Recommendation Report for Planning Permission for Works or Extension to a Dwelling

REF NO: A/110/18/HH

LOCATION: Four Elms
Ham Manor Way
Angmering
BN16 4JQ

PROPOSAL: First floor extension over existing garage to provide accommodation for the sole use of the existing dwelling. Resubmission of previously approved planning application A/16/11 (APP/C3810/D/11/2154095)

Drawing Title:
PROPOSED PLANS

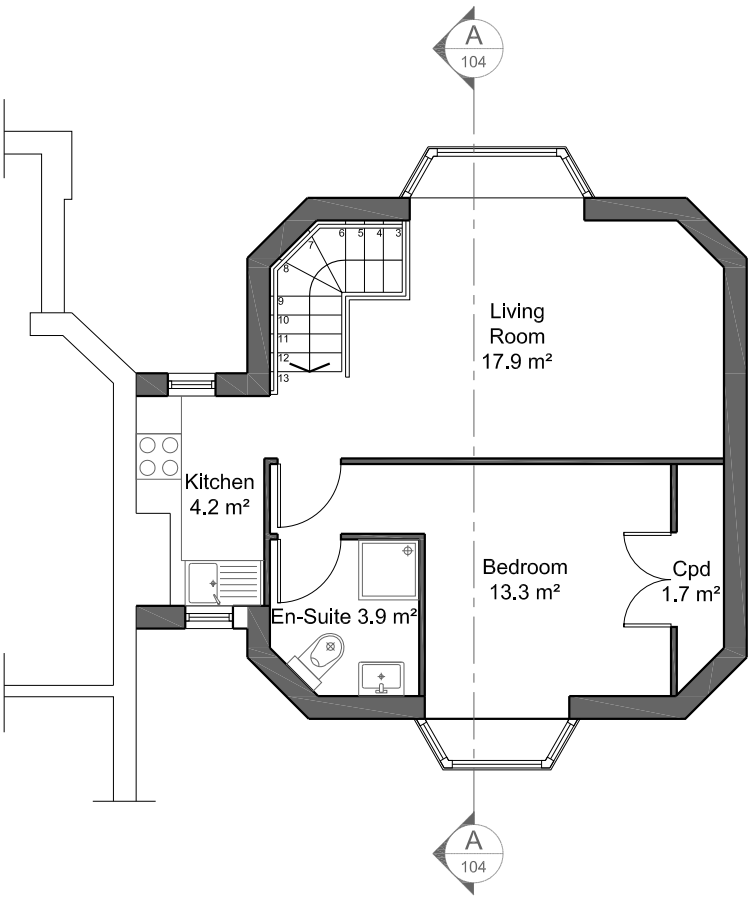
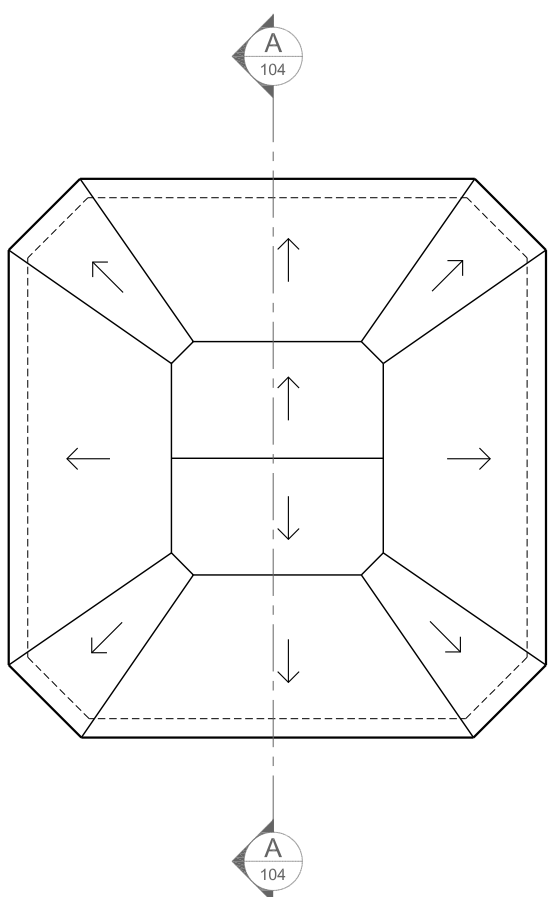
The first floor extension is located only 1.5m from the Northern boundary of the site. The adjacent dwelling has a garage to its Southern elevation, and therefore any potential overshadowing impact does not effect any principal habitable rooms of 'Studley'. As a result of the design its fenestration, the proposed development is not considered to cause any unacceptable loss of privacy to the adjacent occupiers of the application site. This is because one proposed window faces the street scene, and the proposed rear window provides views towards the rear garden. Therefore, none of the new proposed windows provide views that are unacceptable by way of overlooking and loss of privacy.

Drawing Title:
PROPOSED ELEVATIONS, SECTION A-A

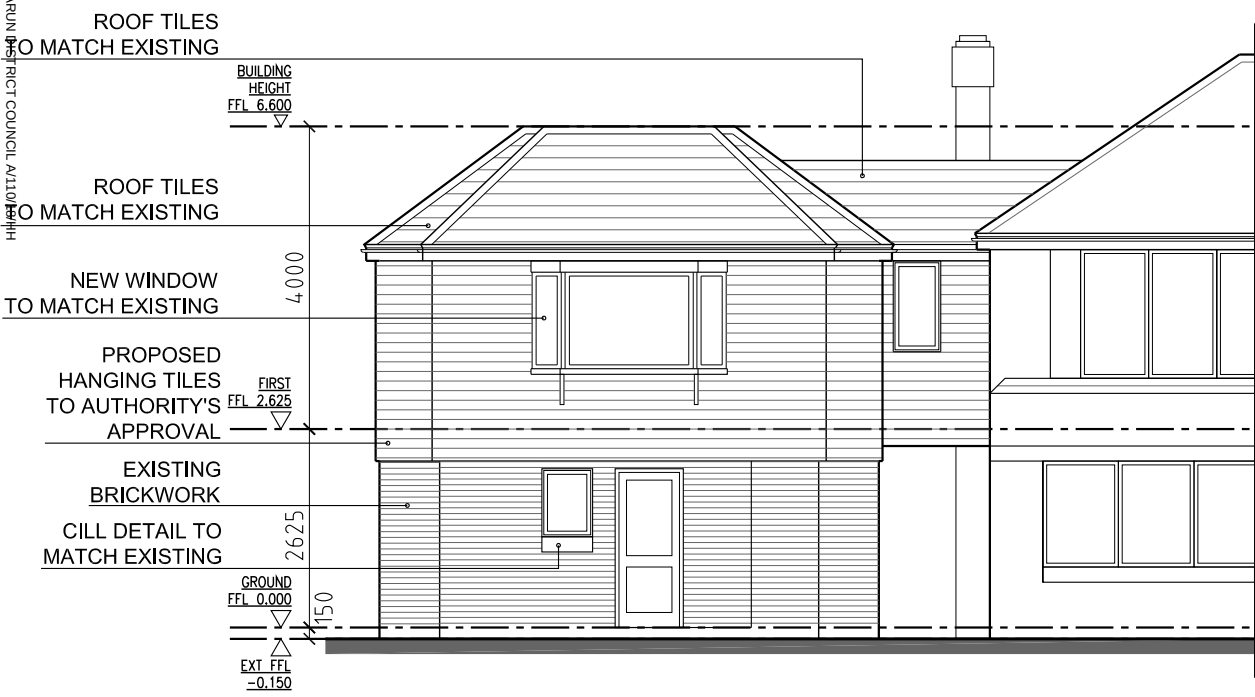
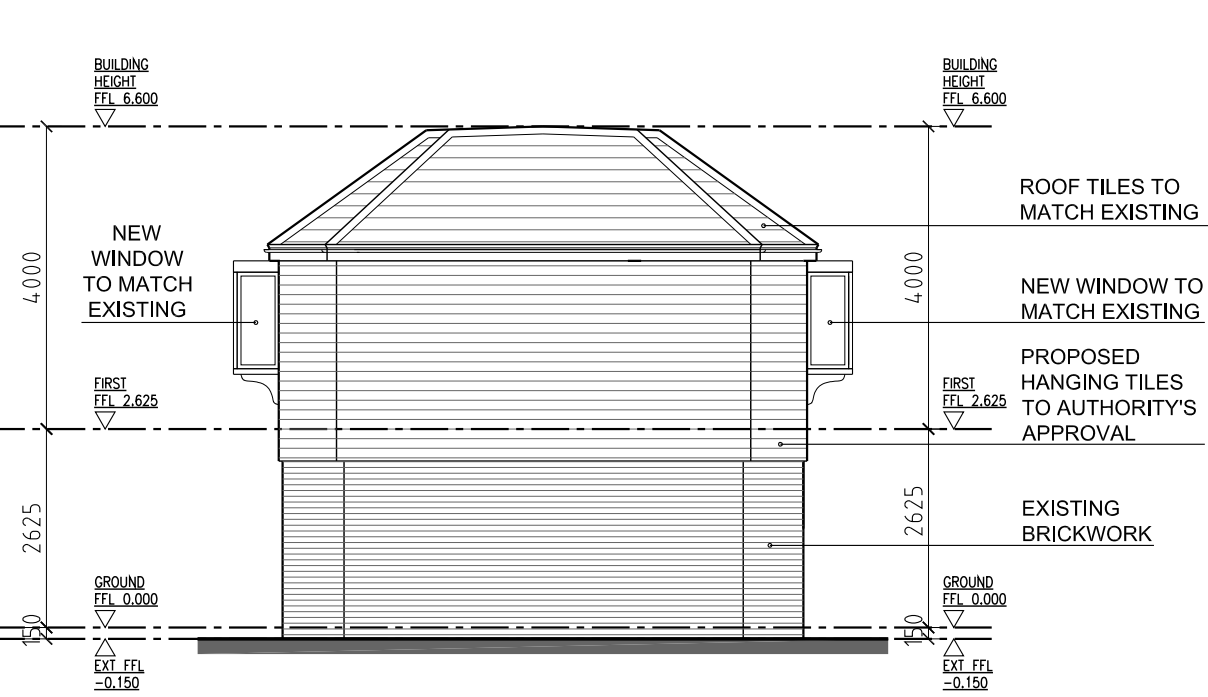
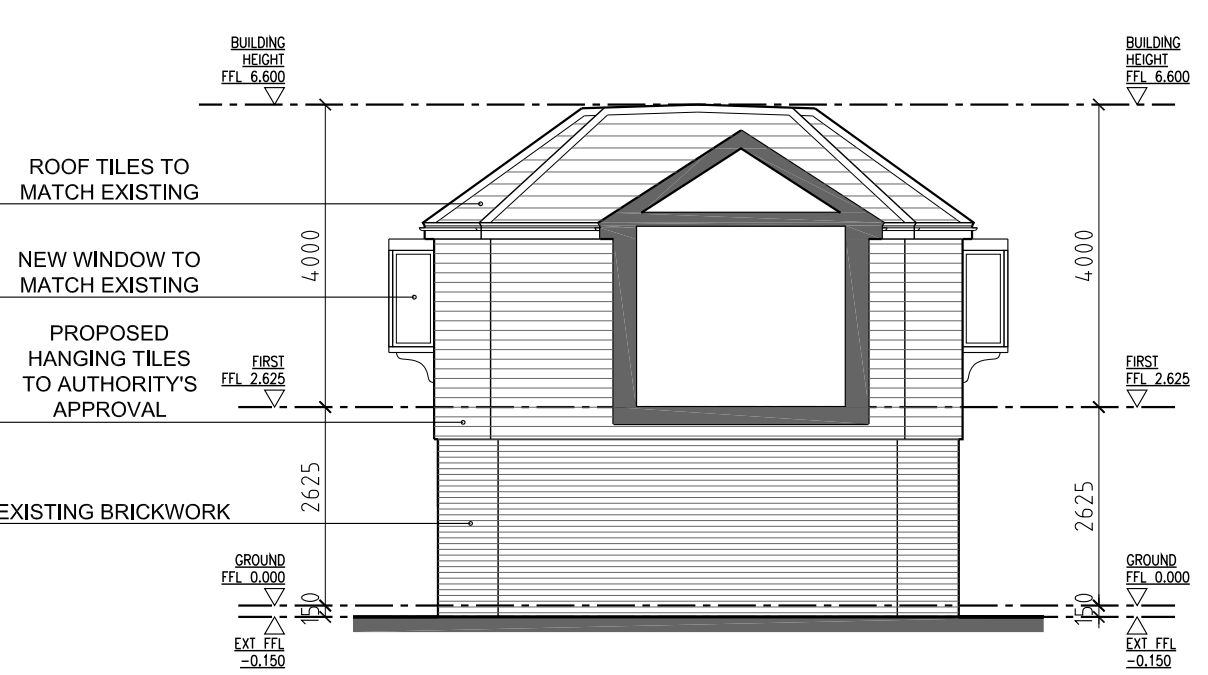
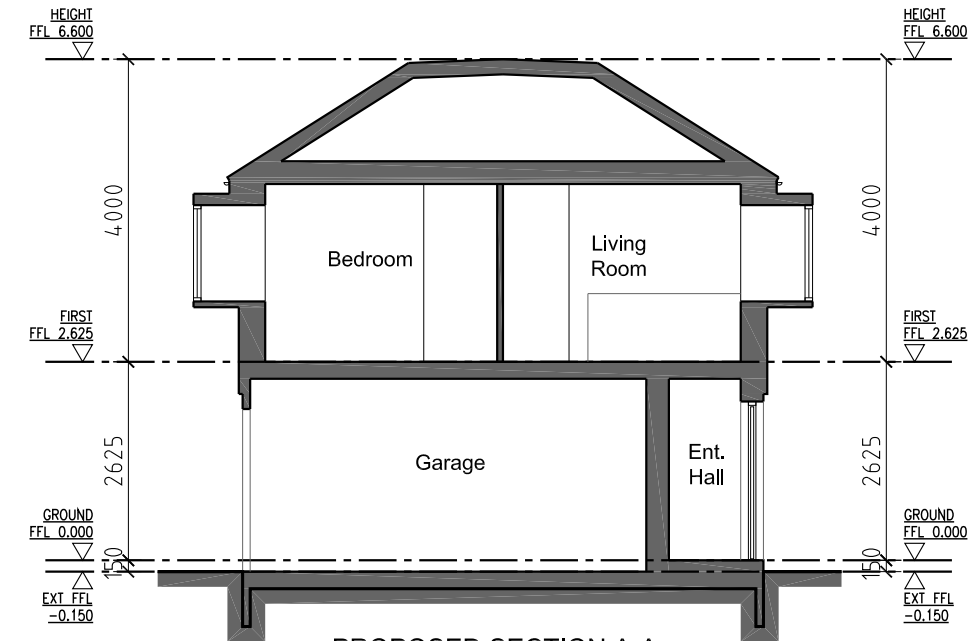
The area is populated by a wide range of varying styles and designs of dwellings, resulting in the area having no consistent distinctive characteristics, with regard to the scale or design of development. The proposed extension would be sited above the existing garage, and resultantly, would be visible from the road. Whilst the proposal would constitute a change in the visual appearance of the host dwelling, it is not considered to be detrimental to its established character. The proposed roof mimics the style of the existing garage, and will be made of materials of which match host dwelling, and the garage. The extension brings the maximum height of the garage to 6.6m, which causes the proposal to have a ridge height 14.28% lower than that of the host dwelling. Resultant of these factors, the proposed development is considered to have no significantly harmful impact on the established character of the area, as it is considered to appear subservient to, and well integrated with, the host dwelling.
